TRANSPORT ASSESSMENT ADDENDUM

Project:	Land off Ploughley Road, Ambrosden, Oxfordshire – 22/02866/OUT	Page 1 of 6
Subject:	Site Access Arrangements	Date: 10/01/2023

Technical Note Prepared by:	Approved for Issue by:
Christopher Miles Transport Consultant	Max Thurgood Director

TRAFFIC CALMING PLAN  
SCALE 1:100

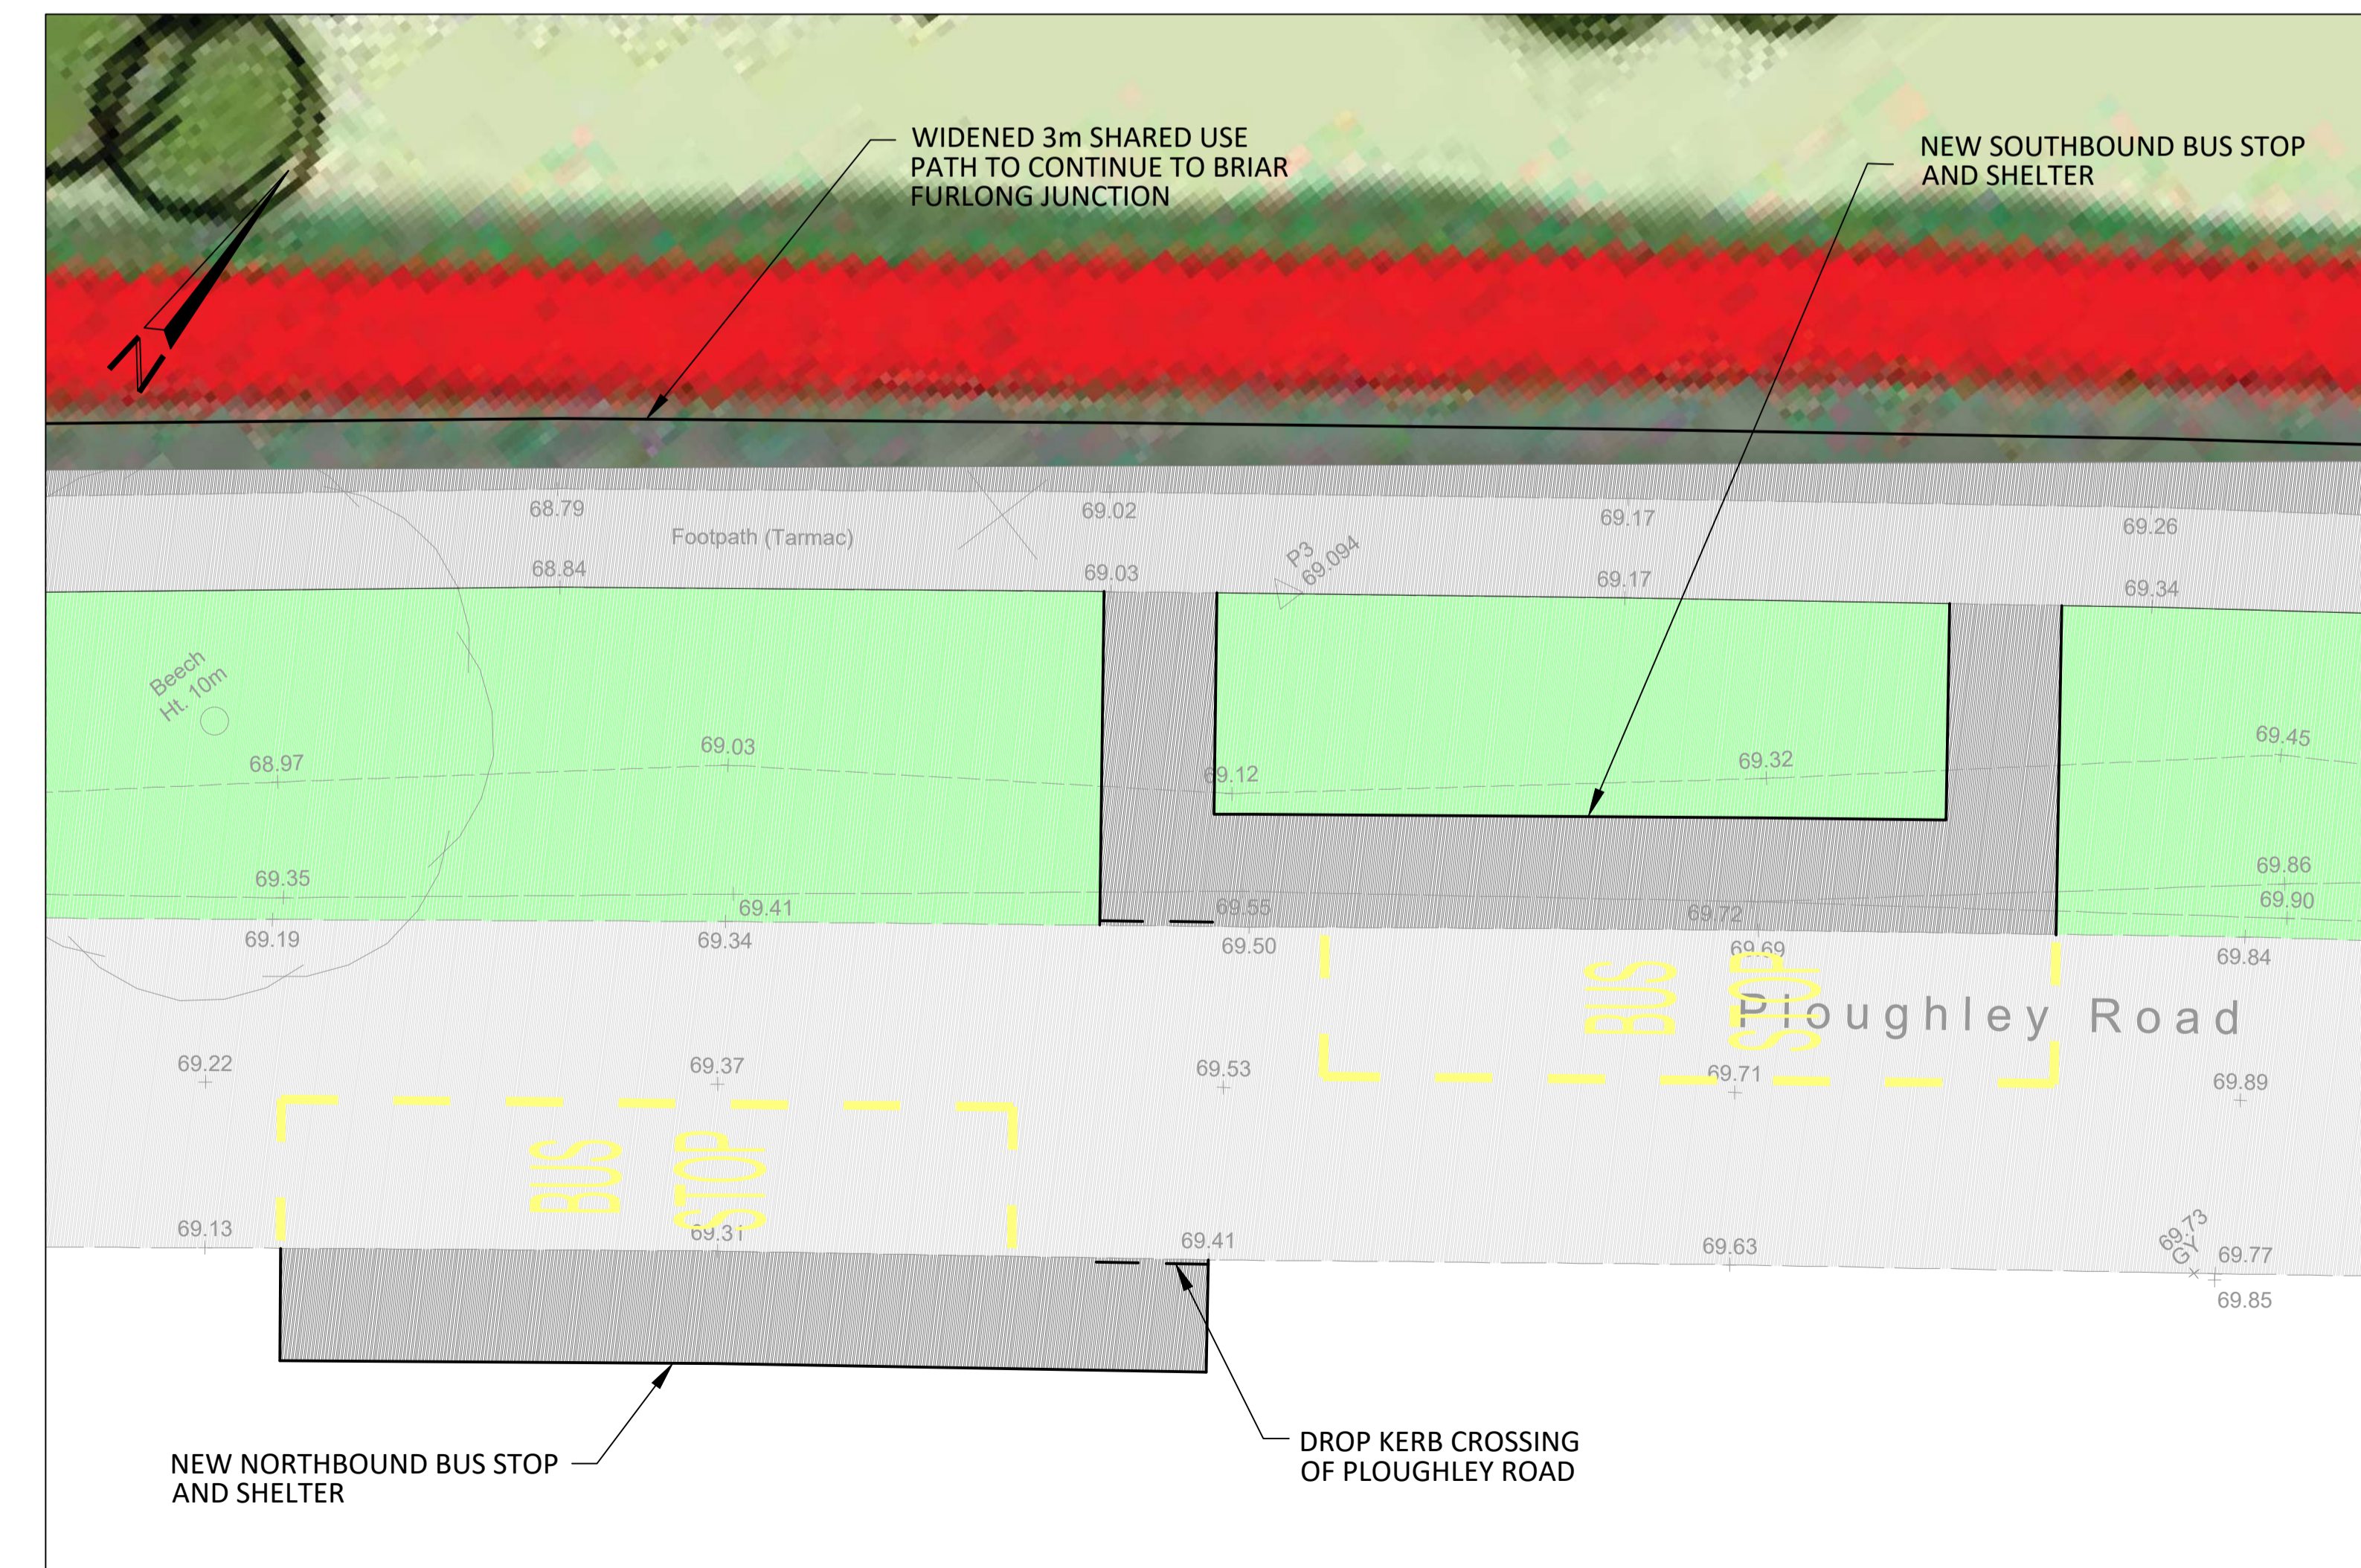
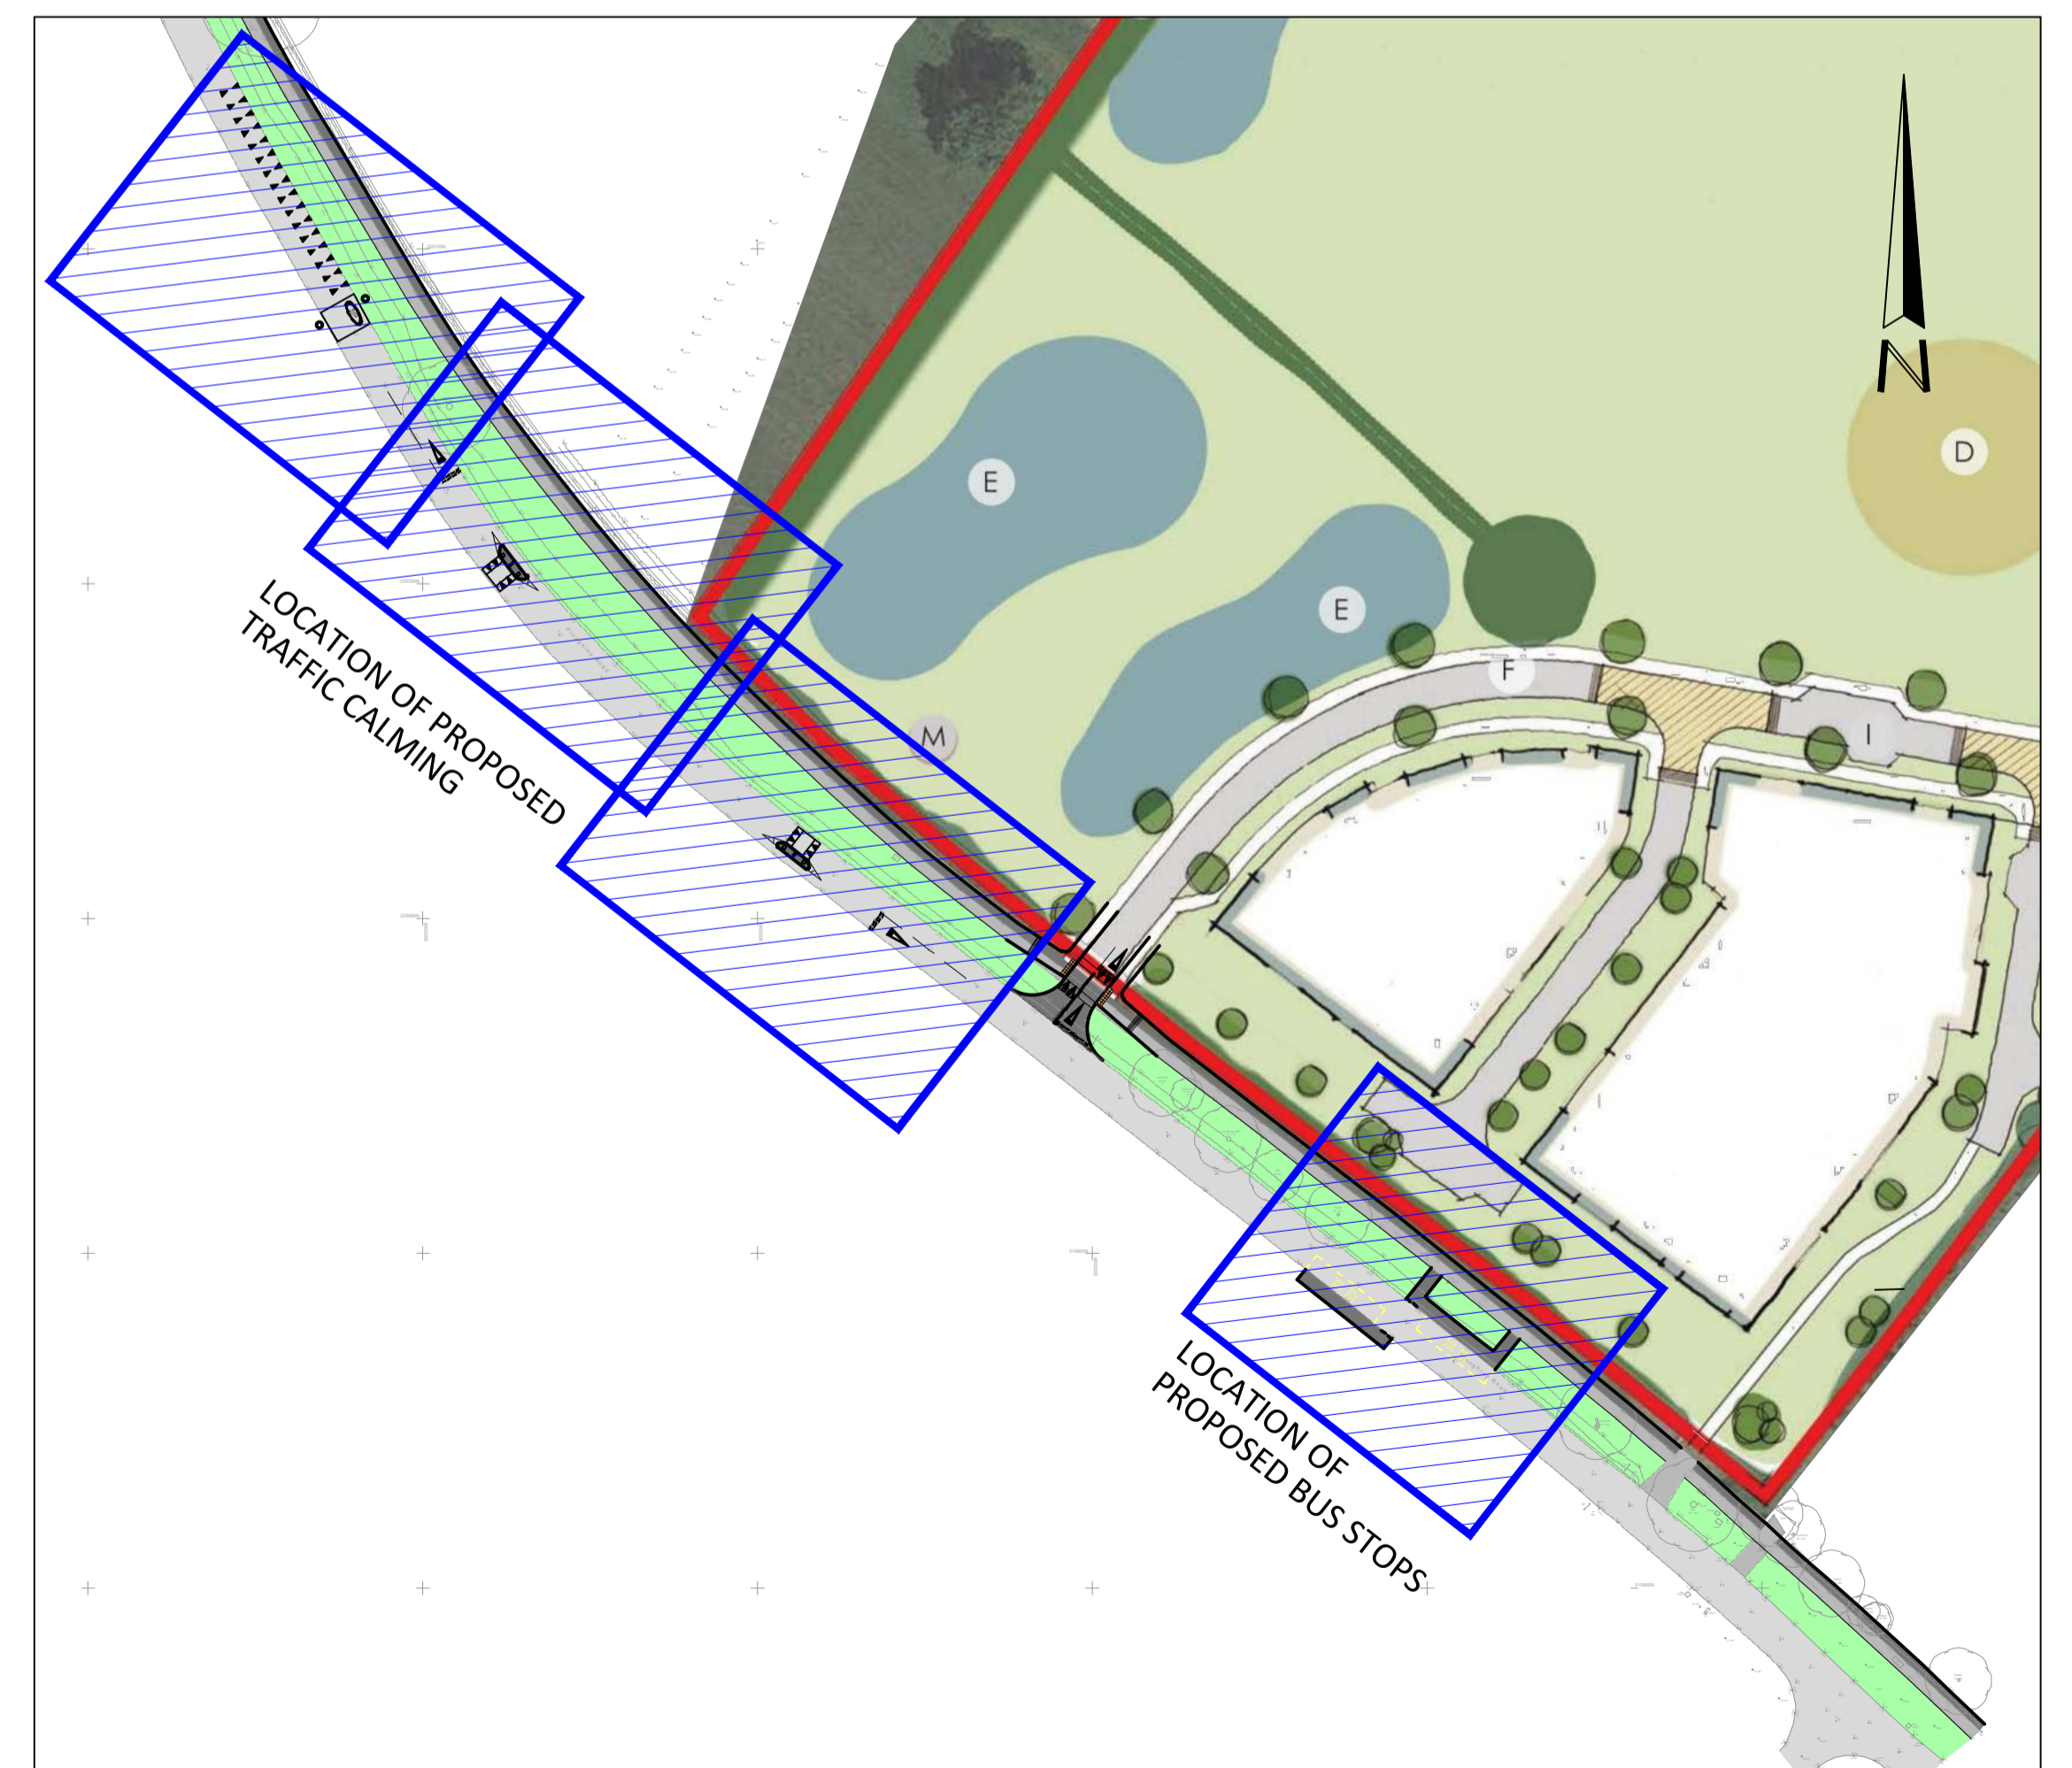
OCC has requested the provision of new bus stops on Ploughley Road in the vicinity of the site frontage. The proposed location and layout of these is shown indicatively on plan 0012_P02 within Appendix B.

The southbound stop would be arranged to provide easy access to the shared use path both to the north and the south with sufficient space available to provide a two-bay shelter, pole with flag and timetable casement. A drop kerb crossing point would also be incorporated to enable convenient pedestrian movements over Ploughley Road to and from the northbound stop.

Topographical survey information of the western verge is not currently available, but it would appear from site observations and the extent of the adopted highway (attached as **Appendix C**) that a two-bay shelter, pole with flag and timetable casement can also be provided within the western verge. This would cater for northbound services.
